It is understood that assessment of MP08_0244 MOD 2 is yet to be finalized and therefore the assessment of this MP08_0244 MOD 3 cannot be based on that previous proposal. It is also noted that the proponent's JBA report refers to that MOD 2 at several places. Council's assessment is based on MOD 3 as a stand alone and not contingent on MOD 2. Therefore, the comments provided below are independent and supersede those within MOD 2.

The purpose of MP08_0244 MOD 3 is to incorporate two additional sites, 39 and 41 Lindfield Avenue, into the development. This amalgamation is considered to be generally beneficial to the coordination of development on the block.

1 1B TYPE B - PRE-ADAPTATION (105A,112A,205A,212A,206B,305A,312A,405A,412A)
6001 SCALE 1 : 50

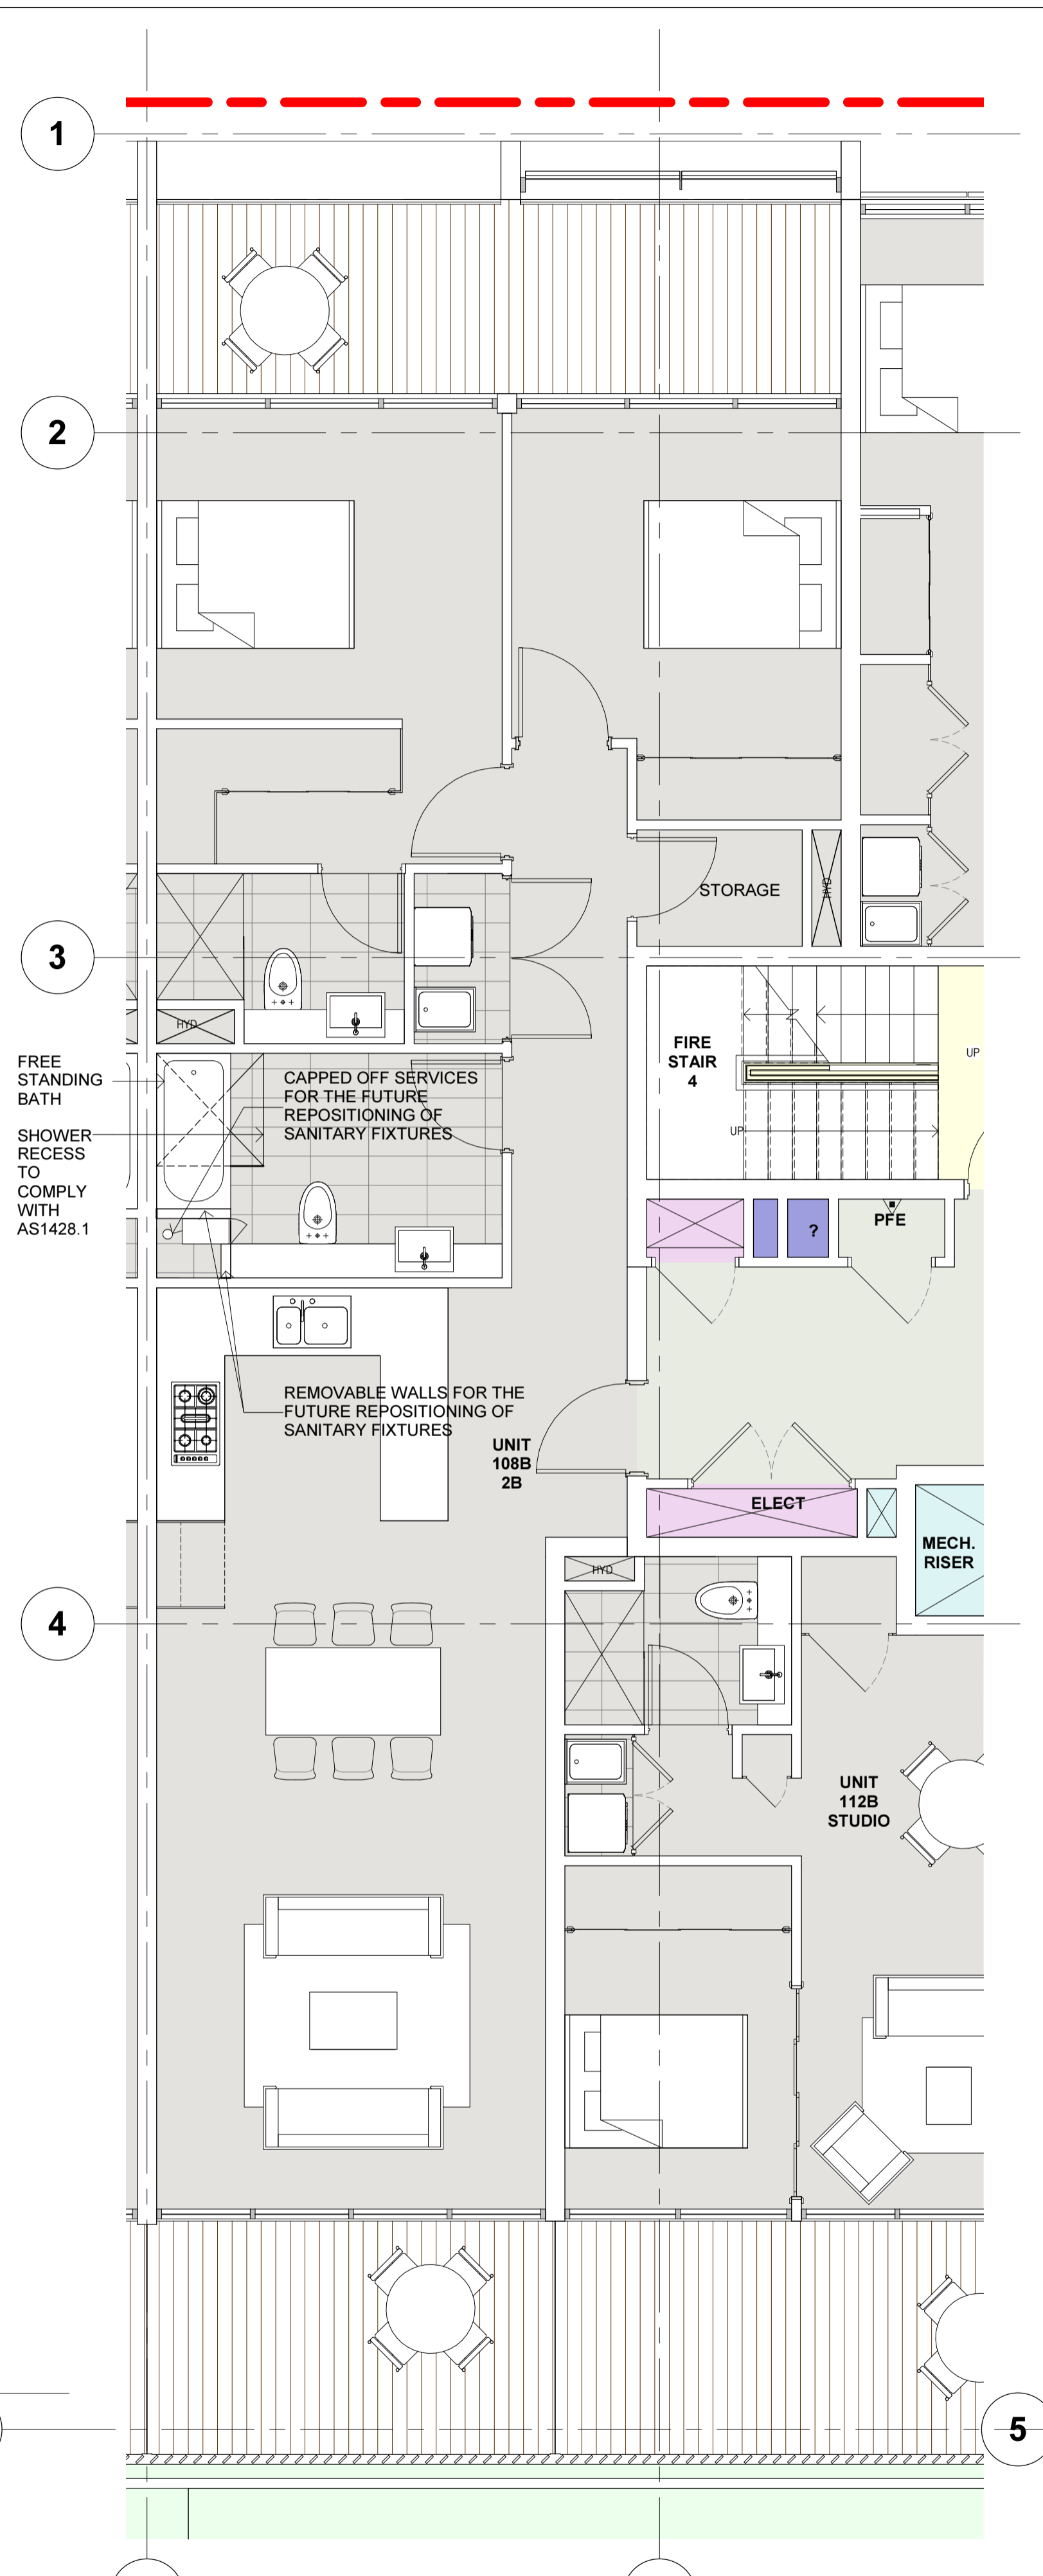
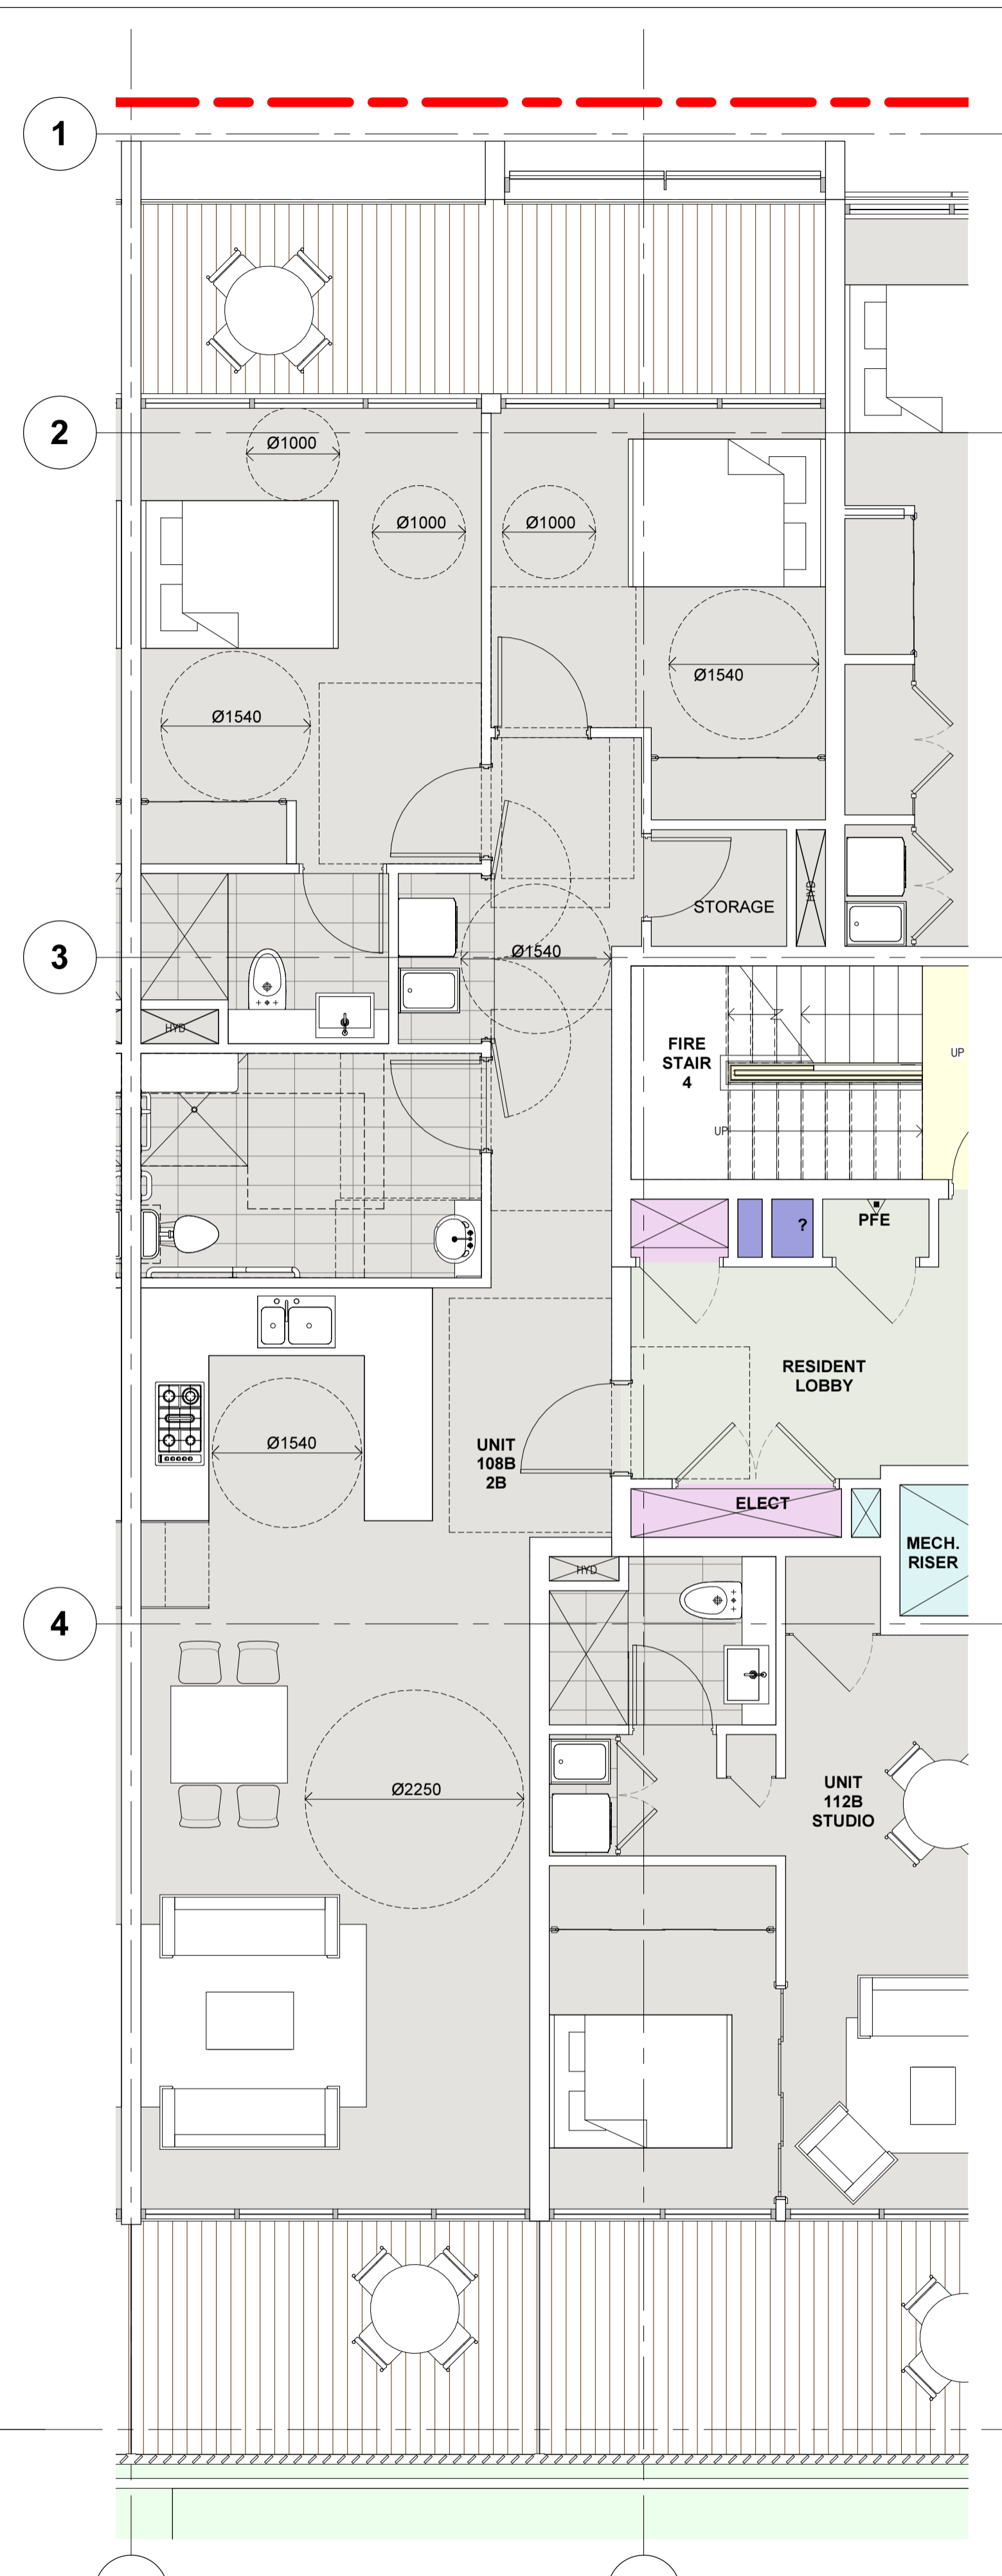
The 'Adaptation Detail Plans' Drawing No. 6001 shows that the accessible bathroom in the 2B type B adaptable apartments do not have an AS 1428.1 compliant shower recess at pre adaptation stage. Under the provisions of AS 4299:1995 a Class C adaptable apartment (the standard required by the Local Centres DCP) must have a bathroom which incorporates all the required features identified in Appendix A of the Standard, this includes a shower recess that complies with AS 1428.1. The Access Report acknowledges that the Local Centres DCP requires Class C housing however the project has been assessed against the lesser requirements for Class B housing.

In addition, the adaptable apartments (Architectural drawings, 6001G) do not meet the requirements of AS4299. The 1B type does not provide a 1540mm clearance in the bedroom (as the 2B type does). The 2B type does not provide a 1540mm clearance to the laundry (as the 1B type does) and does not indicate the adaptability of the second bedroom (which is more likely to be used as such given the ensuite in the main bedroom cannot be adapted and so will not be used by a disabled person). Further

to this, the units still do not locate the bathroom suites at the location that will be required for the adaptable unit. Locating the toilet, basin, shower in the same location in both the pre-adaptation and the post-adaptation units will result in units that will not require expensive plumbing adjustment in the future. This is likely to prevent the unit being converted in the future due to costs in the vicinity of \$15-20K per bathroom. Part of adaptability is to make the process of the refit simple and inexpensive. It is recommended that the apartment layouts be revised to address this issue. Requiring purchases of adaptable apartment who require an accessible bathroom to carry out major construction work is inconsistent with the objectives of the Adaptable Housing standards. The bathroom design should be amended to comply with the requirements of AS 4299:1995, this can be achieved through a condition of consent.
